APPROVED
 Limited building only review
 Permit holder responsible for full compliance with the code

149 DAUPHINE STREET
 ADDRESS
 FUGUAY-VARINA, NORTH CAROLINA
 BUILDER: FAMILY BUILDING COMPANY
 DESIGNER: DESIGNER COMPANY NAME

FIRST FLOOR PLAN

FIRST FLOOR PLAN
 A=1
 SHEET 1 OF 4

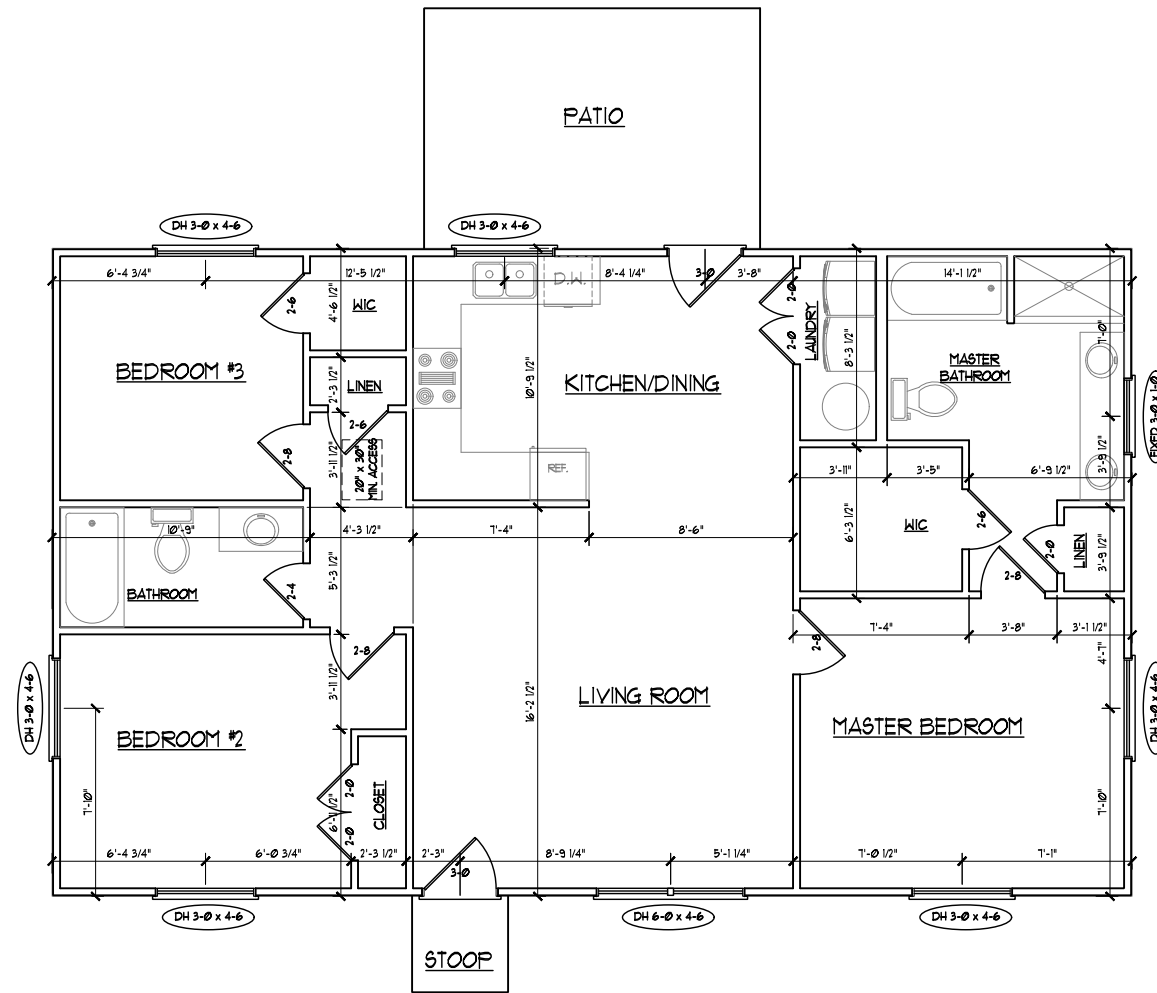
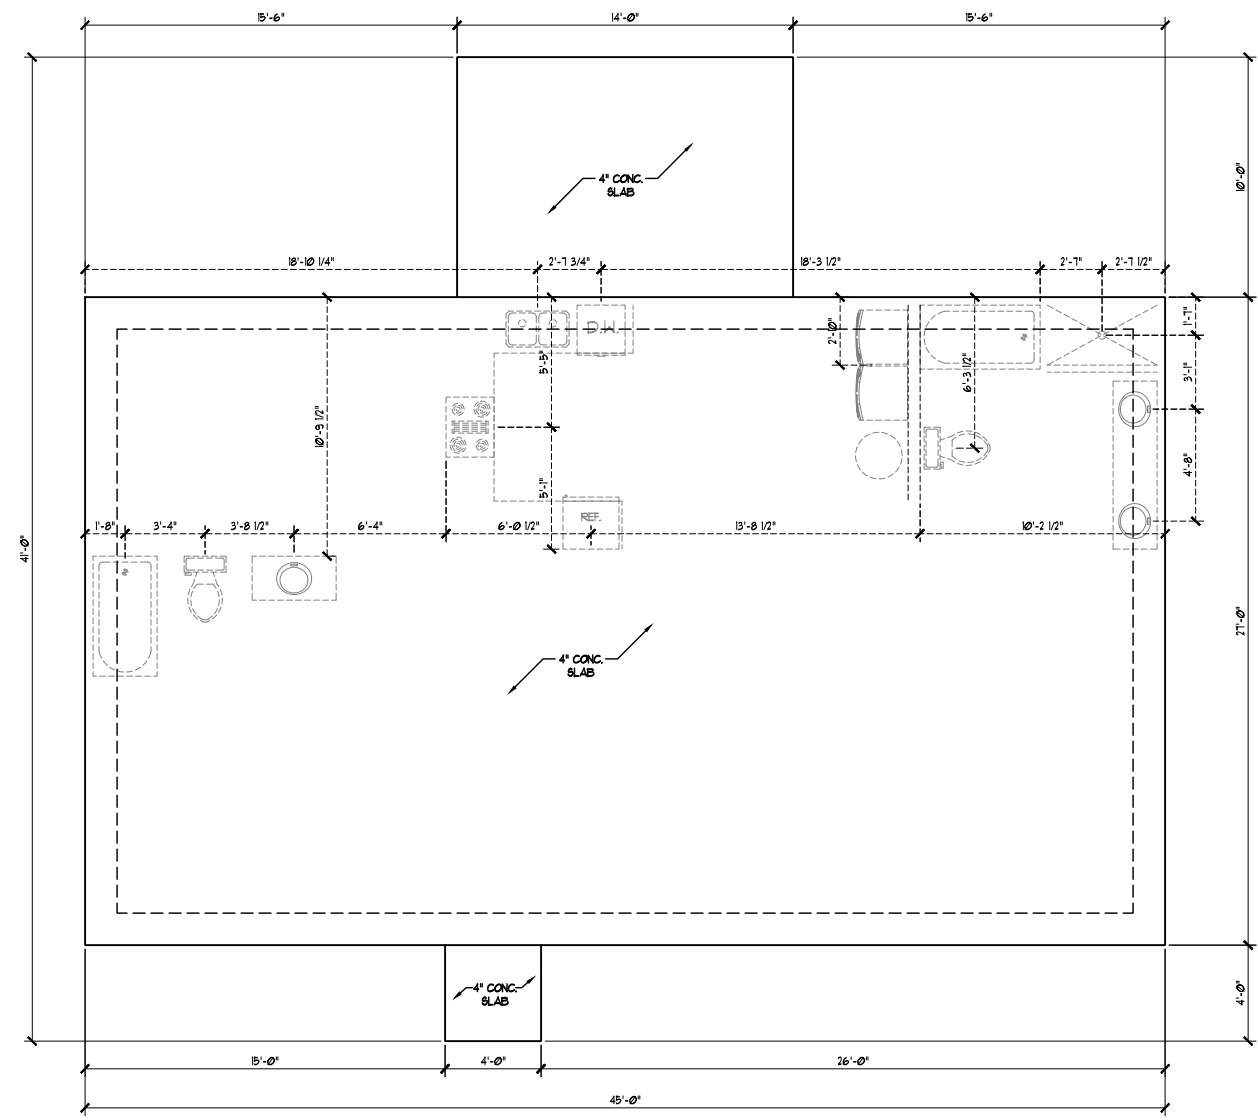
Bedroom windows shall meet minimum egress size requirements. Double hung windows this size typically will not meet the minimum height requirement.
